DELEGATED DECISION TO DETERMINE PLANNING APPLICATIONS

Reference No: 2020/62/93690/W

Site Address: 84, Hammond Street, Fartown, Huddersfield, HD2 1BA

Description: Demolition of existing garage and erection of two storey side and single storey rear extensions

Proposed First Floor Plan Scale 1:100

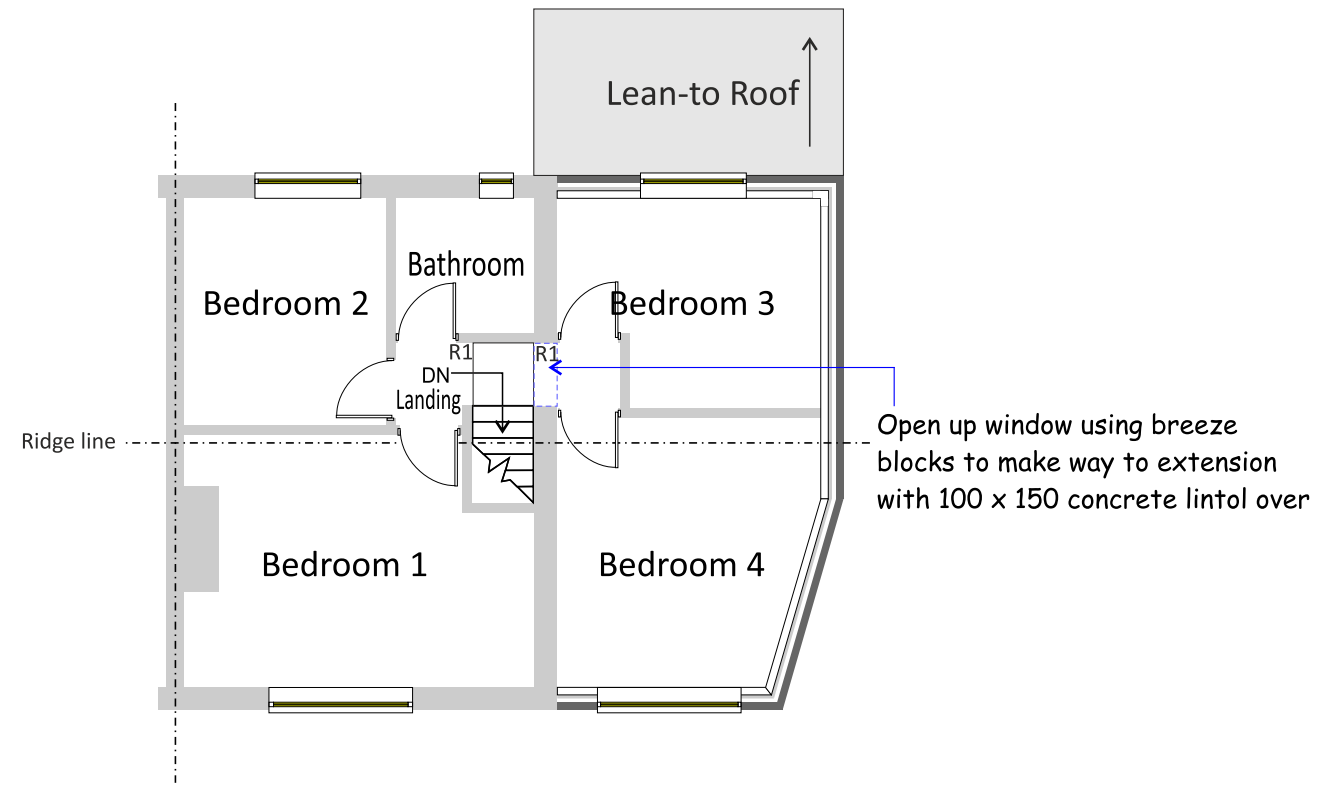
However, the proposed side extension would be built almost on the boundary, where the potential for terracing effect has to be considered. To overcome this, it is recommended that the first floor to be setback by 0.5m and the ridge height reduced to reflect the set back. In order to reduce the possibility of terracing effect that could occur by breaking up the frontage and the roofline. The agent has been advised of this, however no amended plans have been received and as such the application has been determined on the submitted details..

In conclusion it considered that the extension would be harmful to the character and appearance of the host dwelling creating the potential for terracing effect, given that the front elevation would be flush and built close to the shared boundary with No.82 and would not accord with Policy LP24 (a & c) of the Kirklees Local Plan or Chapter 12 of the NPPF.

1. The proposed side extension, by reason of its siting, scale and design would result in the establishment of an undesirable terracing effect in relation to the adjacent dwelling. Furthermore, the overall scale of the proposed extensions would not be subservient to the original dwelling. For these reasons the proposal would result in an overly prominent and incongruous form of development within the street scene. This would be harmful to visual amenity of the area and contrary to the aims of the National Planning Policy Framework paragraphs 127 and 130 and policy LP24 (a and c) of the Kirklees Local Plan.

The agent has been contacted via email and phone, requesting amended plans to show the first floor set back 0.5m with the ridge line set down to reflect this. Along with a plan showing 3 parking spaces, however none have been received.

Proposed Ground Floor Plan Scale 1:100

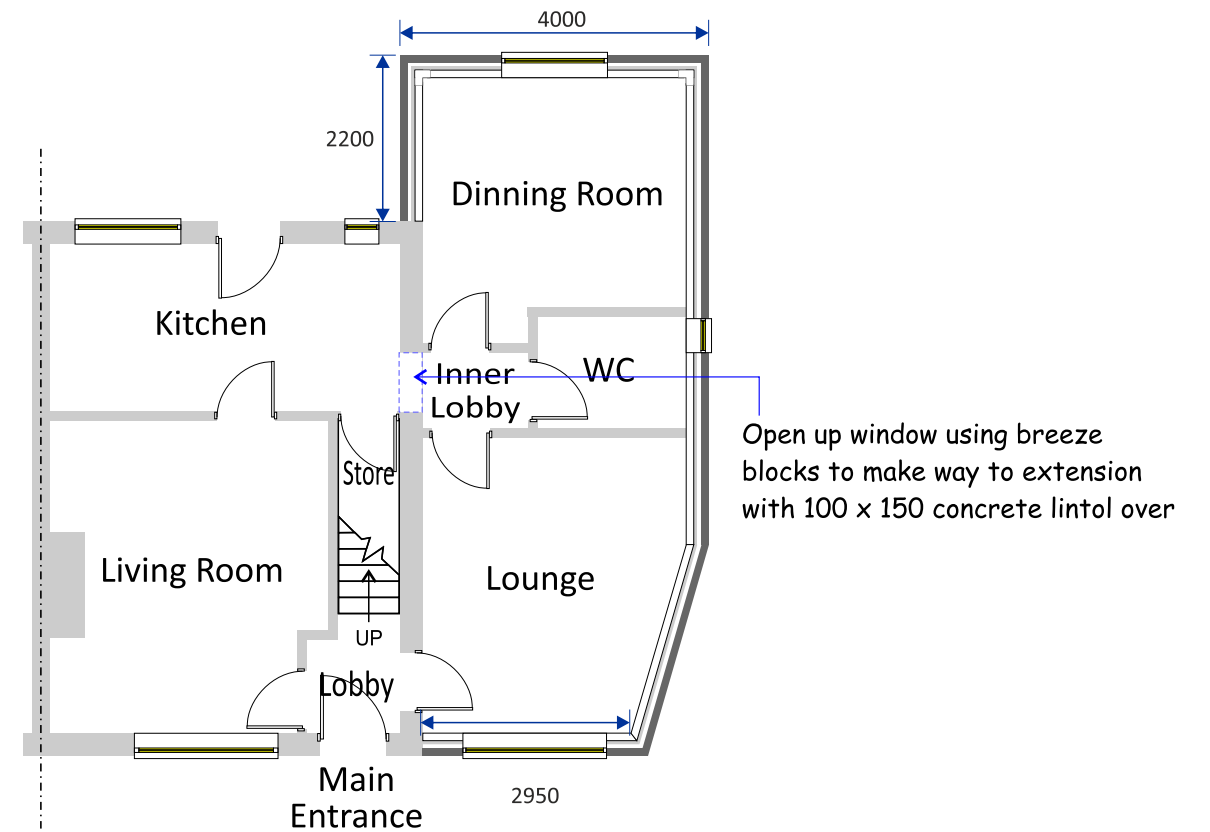
The submitted plans don't indicate any off-street parking within the curtilage. The existing arrangement would be changed in that the existing garage will be removed and the drive length reduced, furthermore the application will increase the number of bedrooms from two to four bedrooms along with increasing the scale of the building. Under the requirements of LP22, three parking spaces would be required in this case. Therefore given the limited space available the proposal is considered not to comply with policy LP22 of the Kirklees Local Plan.
